**KIRKLEES METROPOLITAN COUNCIL
INVESTMENT & REGENERATION SERVICE**

DELEGATED DECISION TO DETERMINE PLANNING APPLICATIONS

Reference No: 2021/62/90604/W
Site Address: 85, Swallow Lane, Golcar, Huddersfield, HD7 4NB
Description: Erection of two storey side and first floor extensions
Recommending Officer: Sam Jackman

DECISION - REFUSED

STATUS			PROVISIONAL		
PROJECT			85 SWALLOW LANE		
TITLE			PROPOSED FIRST FLOOR PLAN		
CLIENT			ADAM LAMBERT		
DRAWN BY	CHECKED BY	DATE			
JLH	LM	08.02.2021			
SCALE (@ A1)		PROJECT NUMBER			
As indicated		HD.21.96			
DRAWING NUMBER		REV			
HD.21.96.PP.02		B

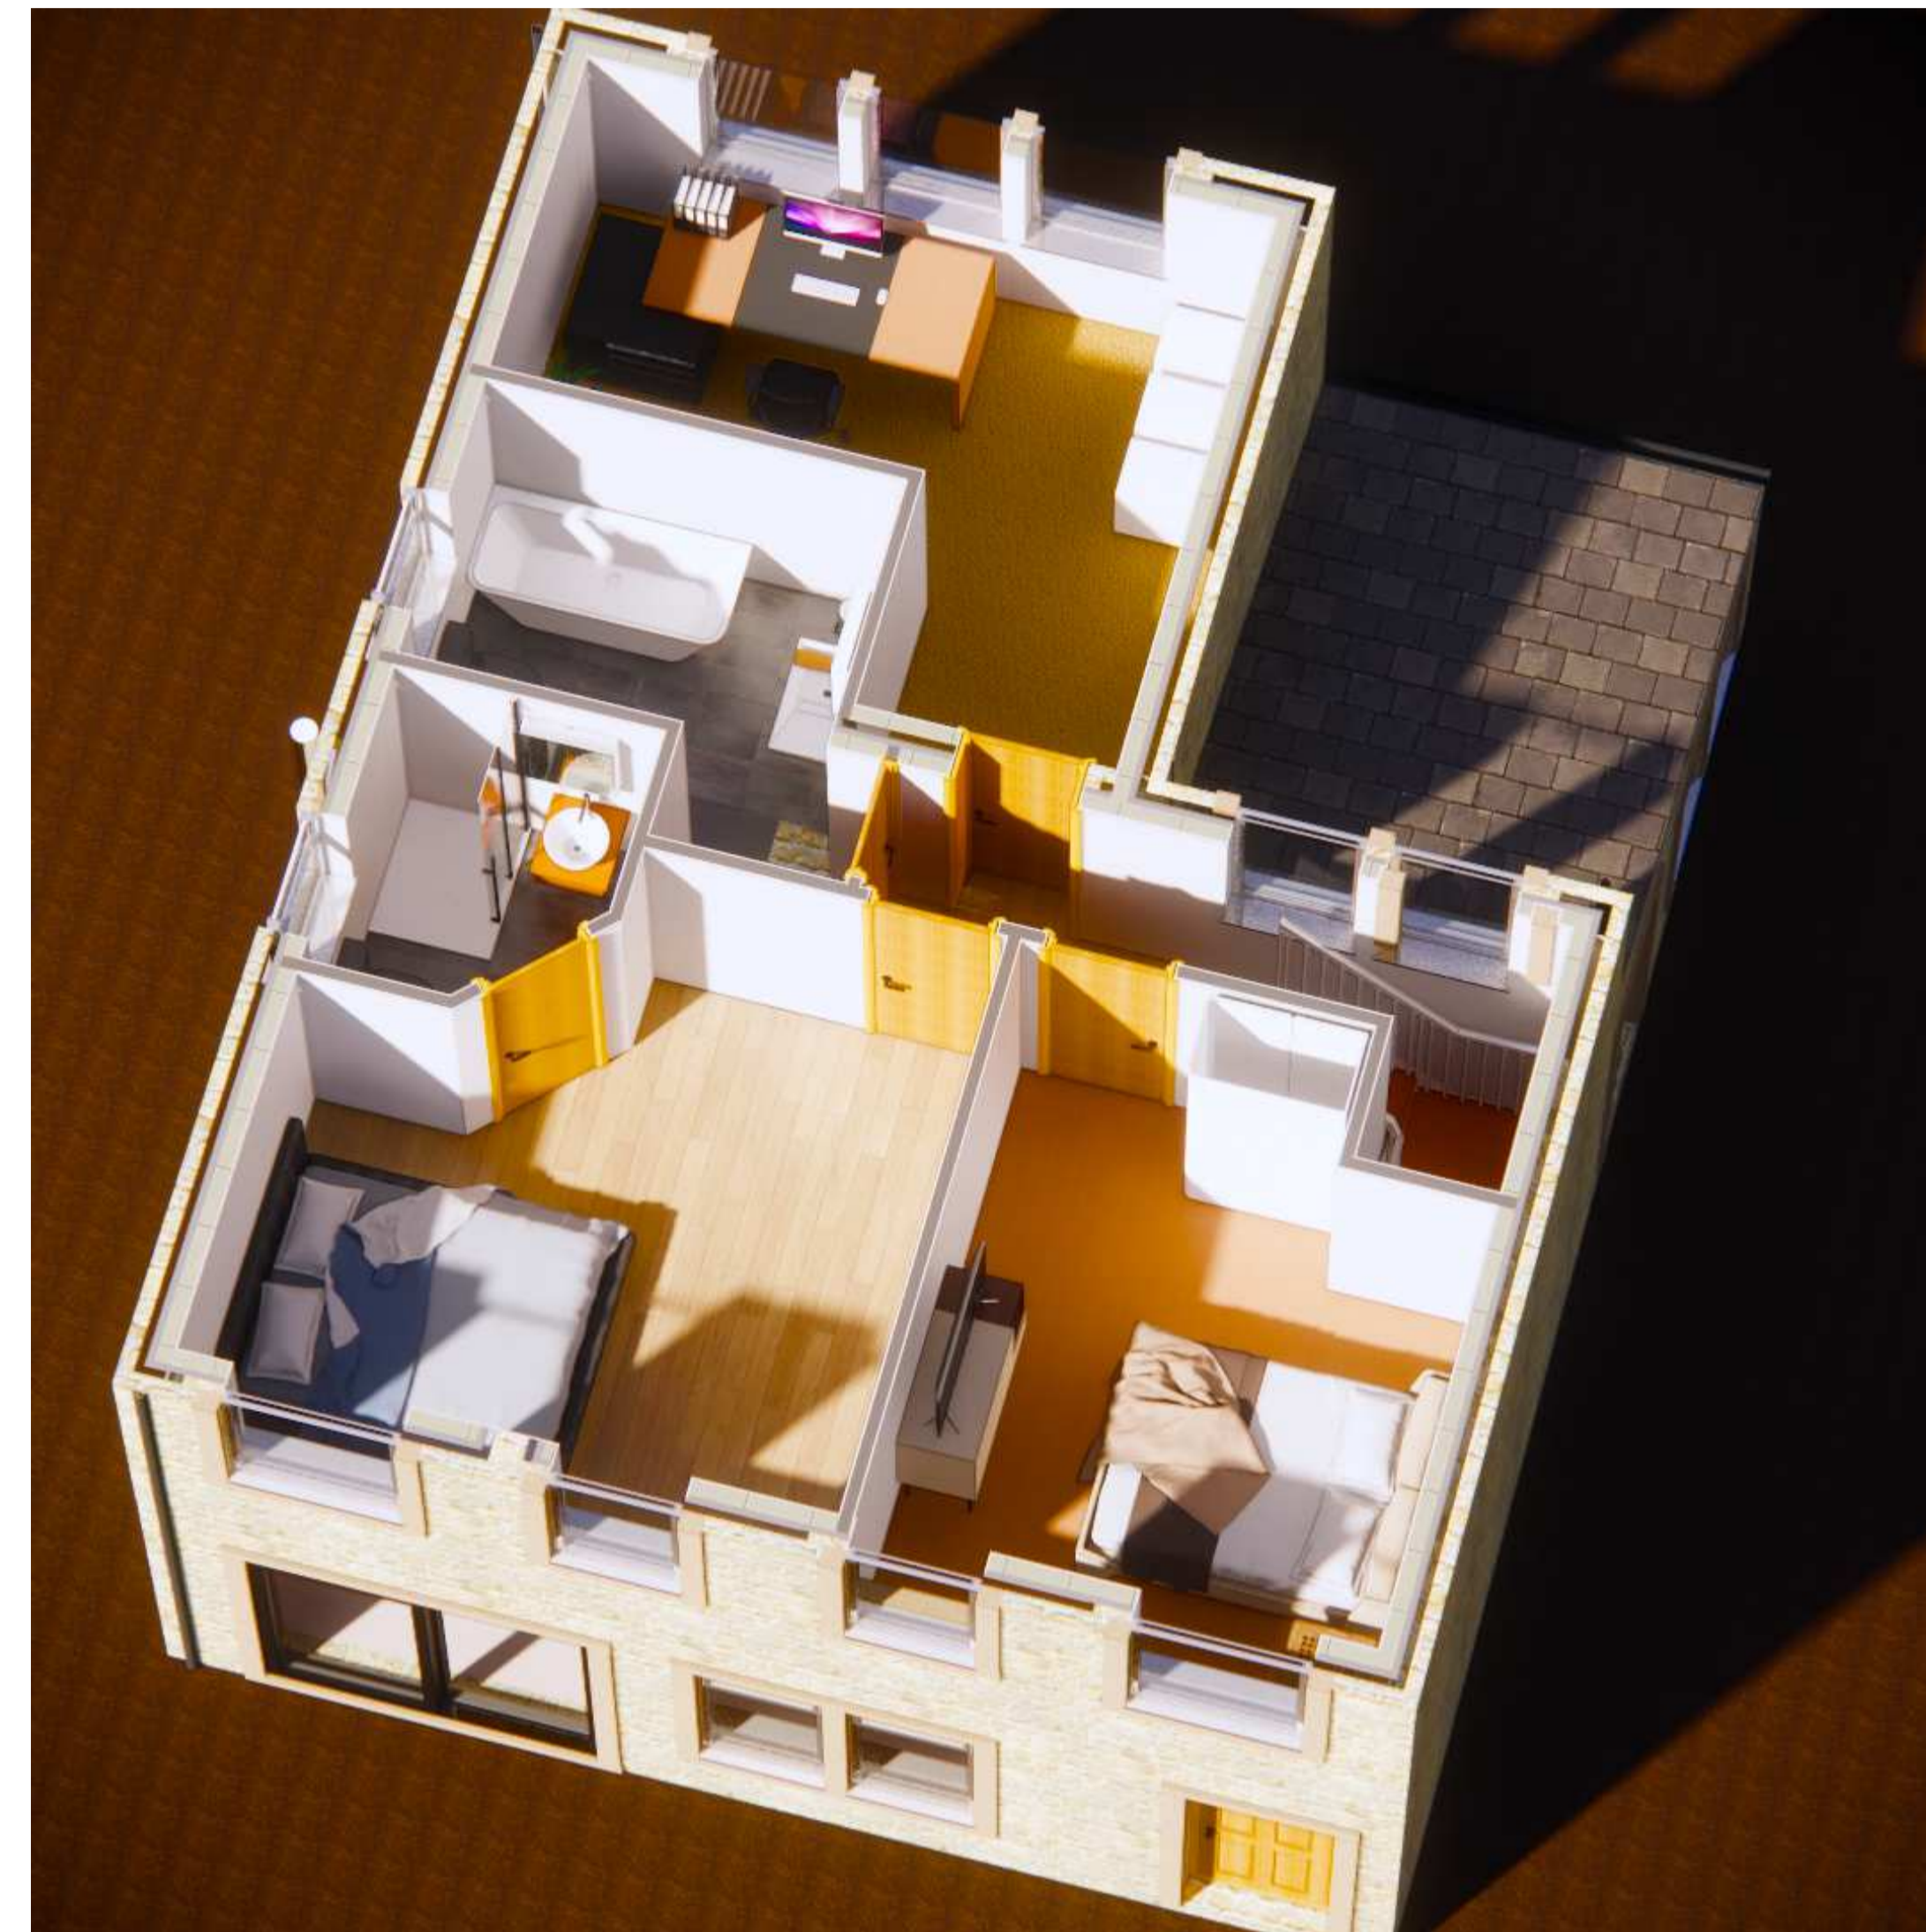
floor double window which currently lines up with the ground floor window would be separated by new stonework to allow the existing first floor room to be divided into two. This will alter the character of this elevation and albeit not facing the road it is the principal elevation, losing the original fenestration details.

With regards to the proposed extension, the property would be extended to the side with a 2-storey extension the full depth of the property, extending the existing single storey 4m outrigger to the boundary and the creation of a first-floor extension projecting 4m above, creating a 2-storey wrap around extension.

Due to the size of the combined extensions, it is considered that they would dominate the property and no longer remain subservient to the host property as required by Policy LP24. This is further exacerbated given that they are to the road frontage albeit considered to be on the rear elevation. It is accepted that the properties either side are terraced properties which are located forward of the host property, where once extended would provide a continuous frontage. However, it is the overall mass & bulk of extension which engulf this relatively small cottage, which results in a loss of character to the host appearing detrimental in scale and thereby being contrary to Policy LP24.
